M3 Junction 9 Improvement Project

Winchester Friends of the Earth

Questions re surface water and river pollution

Study Area used in ES Road Drainage and Water Environment chapter and key identified receptors.

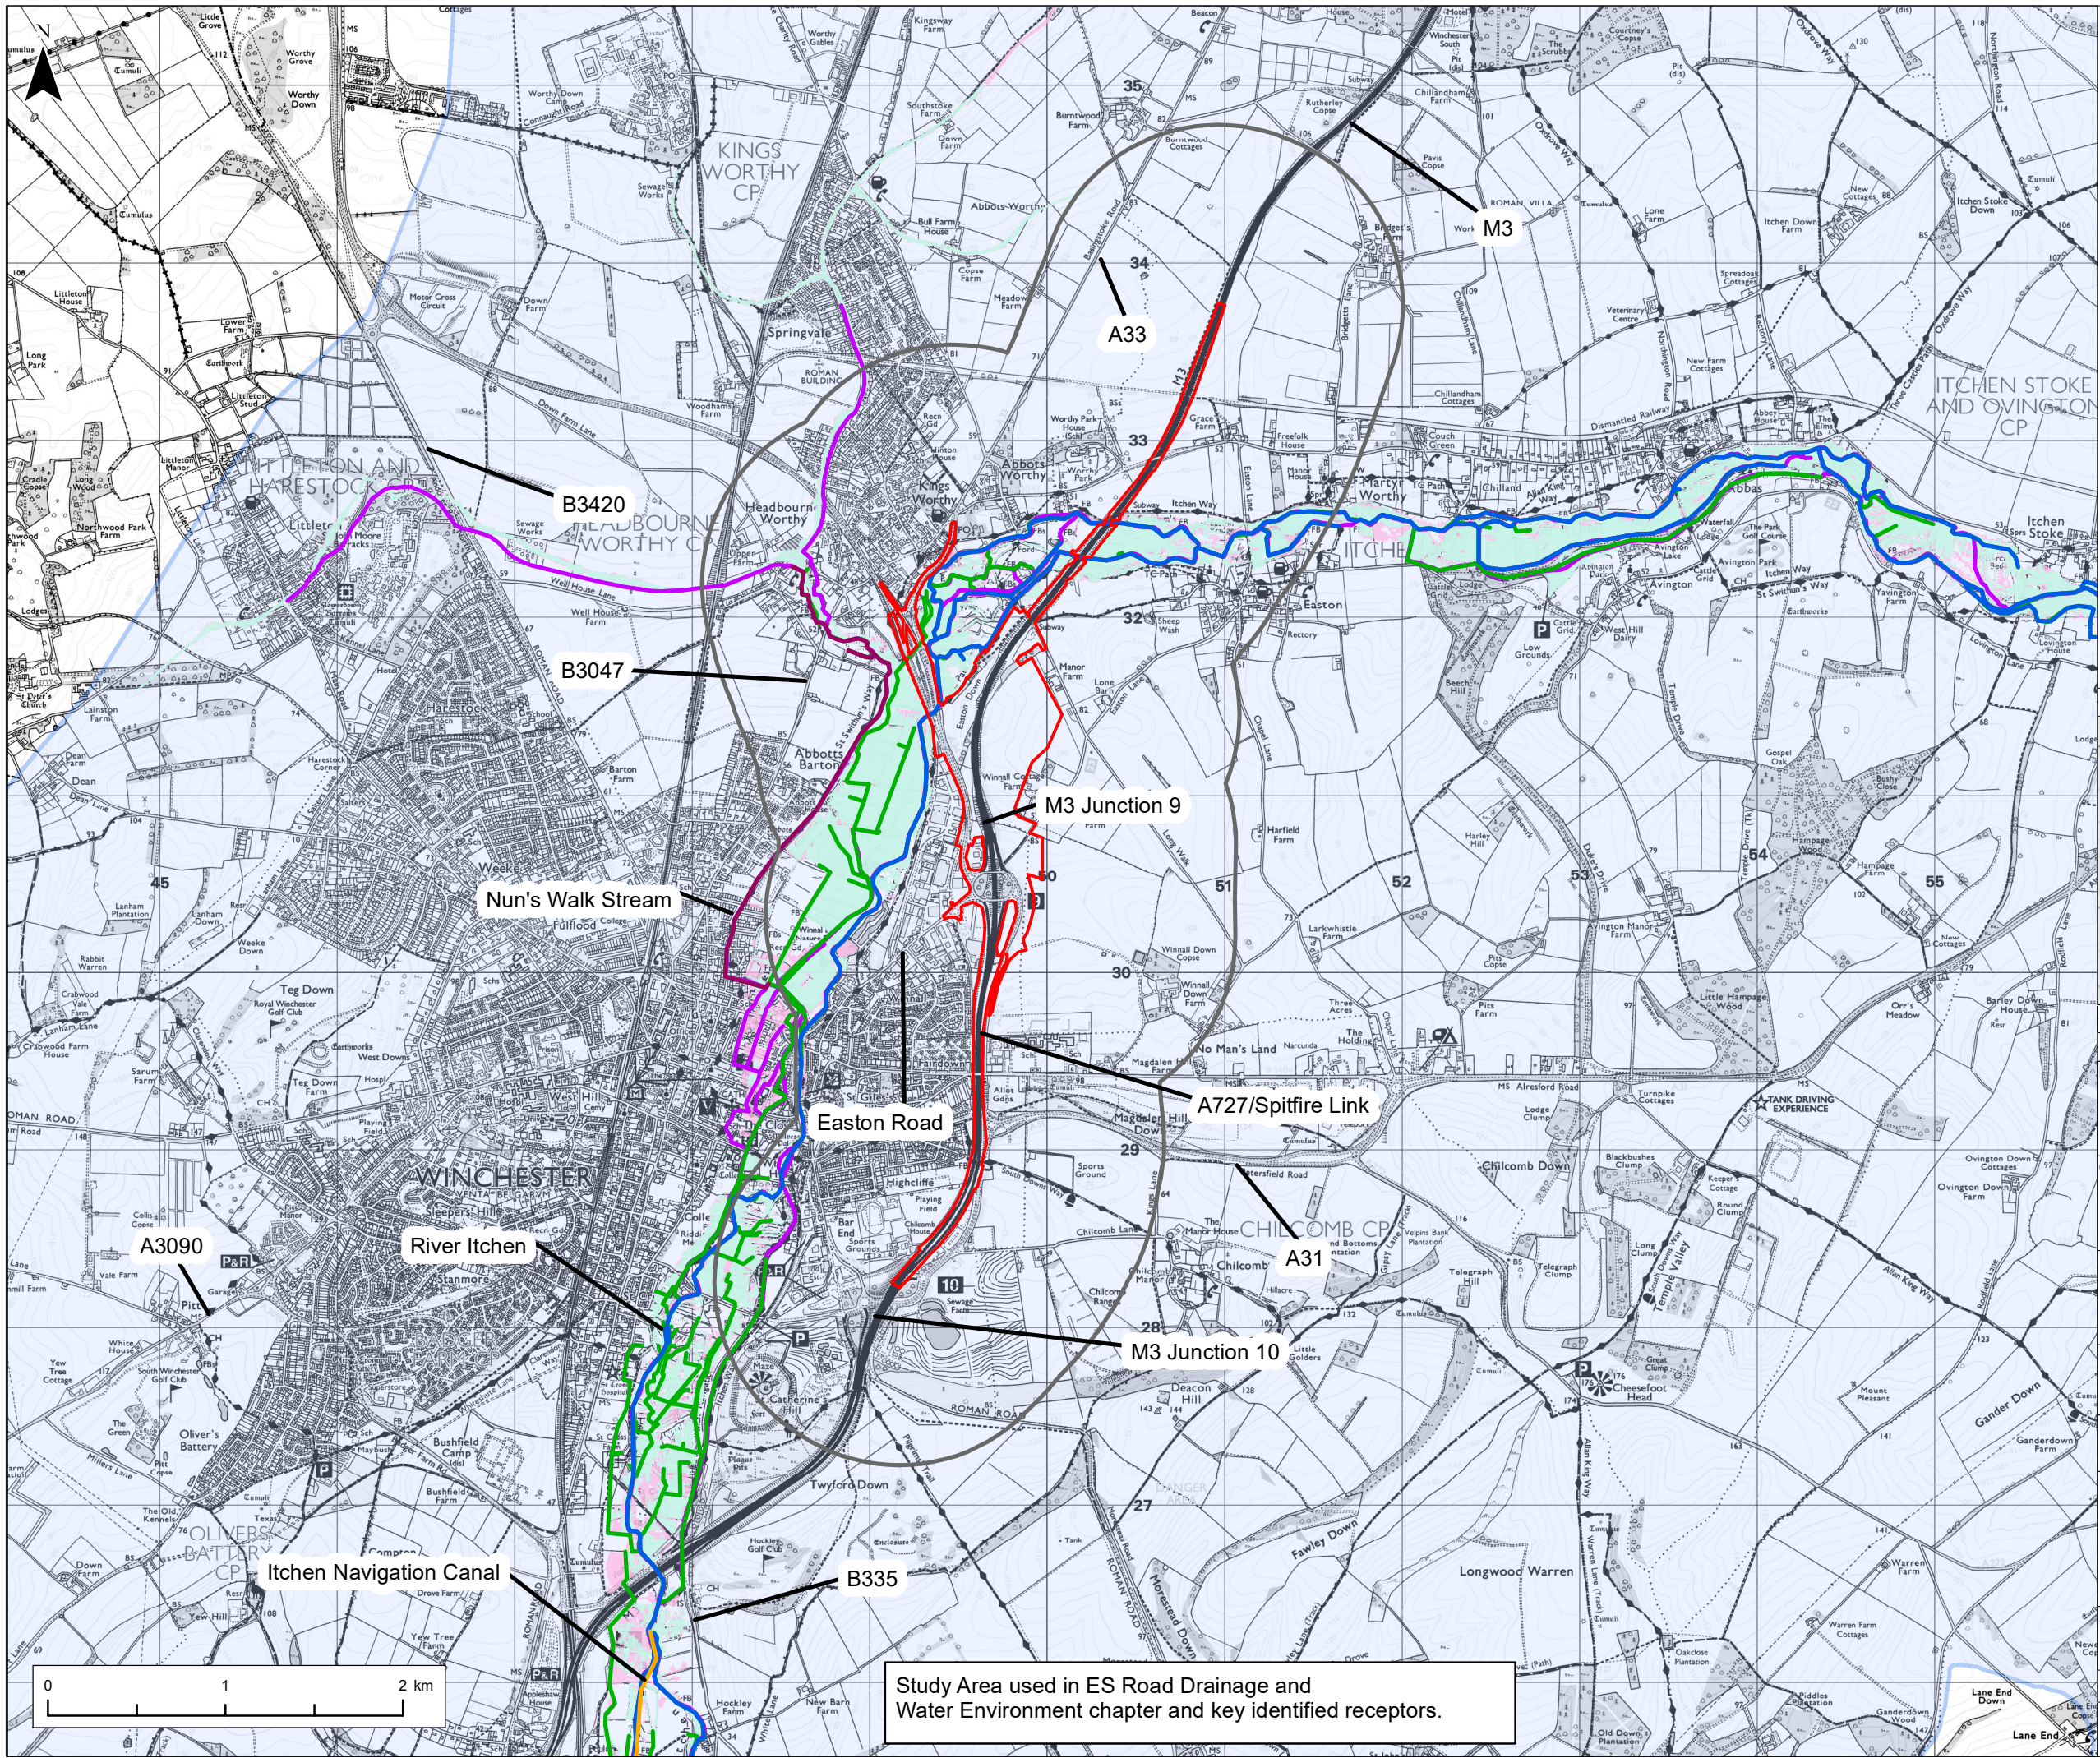
The location appears to be where the M3 crosses the Itchen to the north of Easton Down and west of Easton. In the Chapter 13 document (6.1) I can find no reference to these outfalls or to any problem outfalls within the Application Boundary. At §13.6.20 there is the statement:

The HADDMS shows the condition status of all existing highway soakaways as ‘low risk’ or ‘risk addressed’.

In the light of the above data, this needs explaining.

- 1) Has a field study been made of the outfalls identified above and, if so, what were the results?
- 2) How many outfalls are there in the application area and into what water elements do they ultimately drain (e.g. Itchen, Nuns Walk Stream)?
- 3) How much soil from the ditches in the area has been designated as hazardous waste?
- 4) What results exist from testing the land, soil & water in and around the soakaways and outfalls?
